Response to PROW questions.

Proposed site plan (1:200).

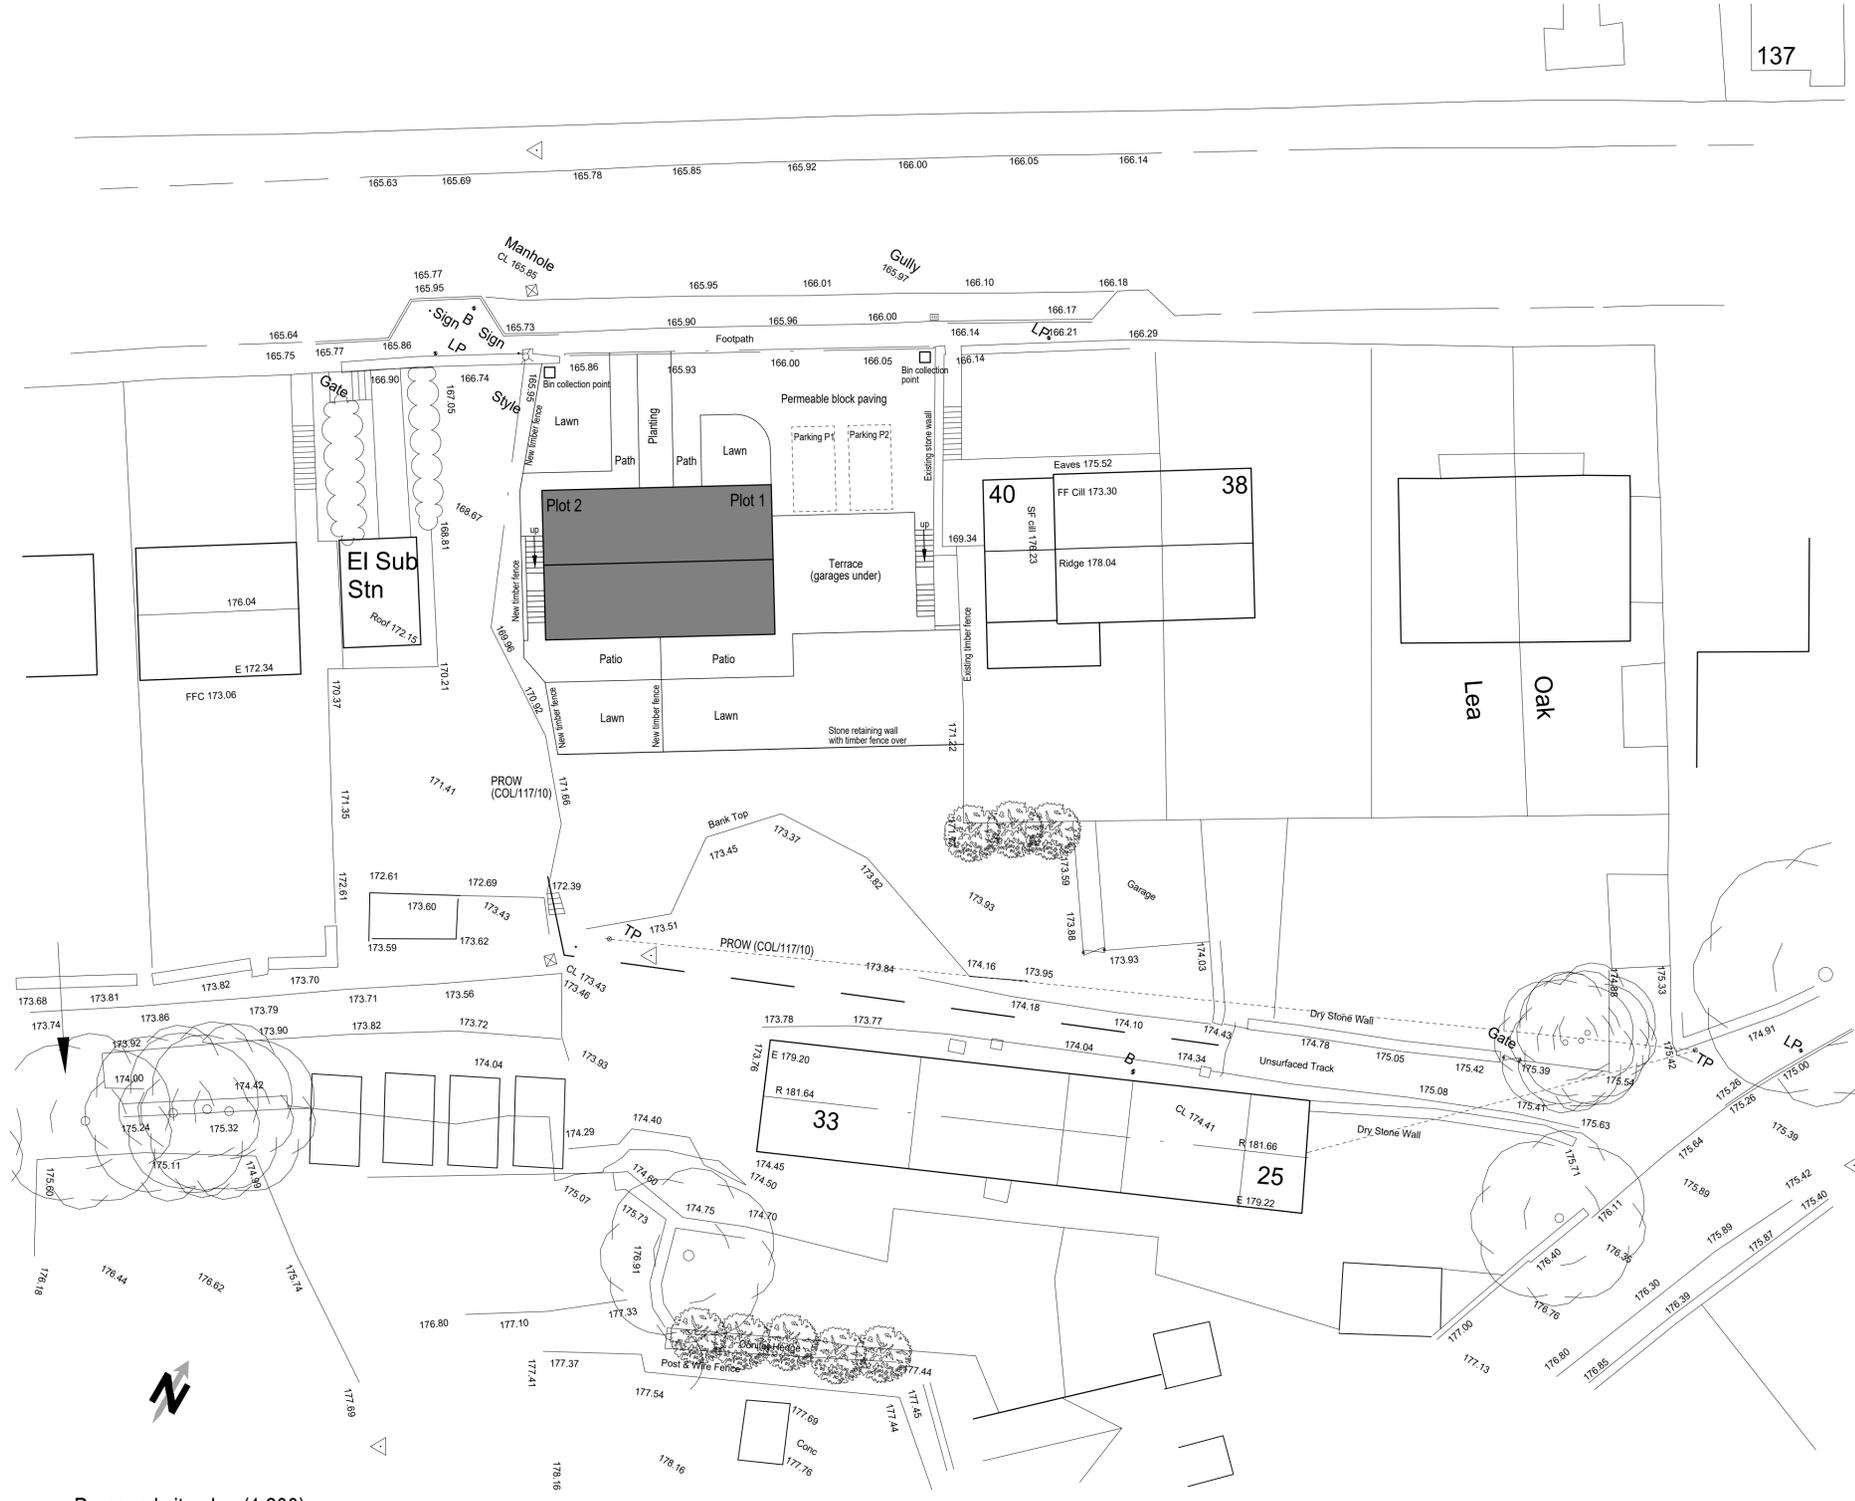
how are the steps going to fit in with the footpath, are they just adjacent to each other and what is to stop the public using the house steps?

The submissions do not appear to match between the 2 plans. This one below, has a right angled bend in, whilst the one you included only has a curve. Also the plan below does not appear to meet the track at the same place.

There will be a timber fence to keep the path and steps separate from each other.

The fence is shown on the drawing.

We think the plan is a fair reflection of what is on the ground as it topographical based.
